Consultation Response from KC Landscape

Application No:	2022/92471
Proposed Development:	Redevelopment of Heckmondwike Bus Station including a new concourse building with waiting room, Changing Places WC, driver offices, 6 No. bus stands, landscaping, and associated works
Location:	Heckmondwike Hub Bus Station, Royle Fold, Heckmondwike, WF16 0HW
Applicant/Agent:	WSP
Planning Officer	Callum Harrison
Date Responded:	26.09.22
Responding Officer:	Landscape
Responding Ref:	LL67

Landscape Context and Concept, Landscape Design

TITLE: **DRAINAGE PROPOSALS**

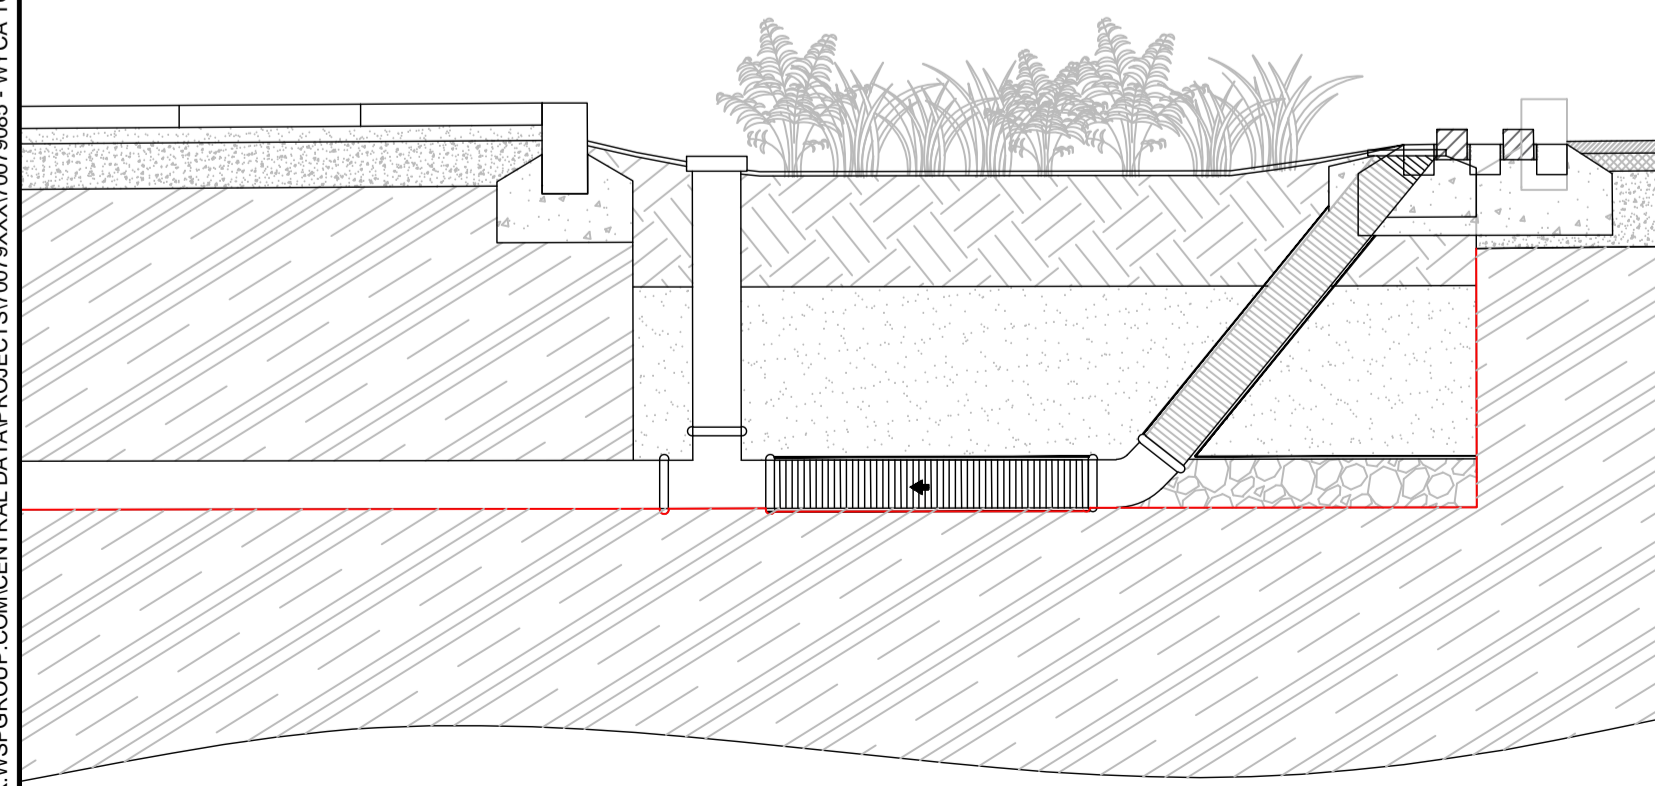
****The landscape proposal shows some very narrow planting and suds areas particularly along the main pedestrian areas and within the main street view, how will the planting proposal be established and maintained in the narrow beds to ensure these are sustainable and create the quality of green street principles?***
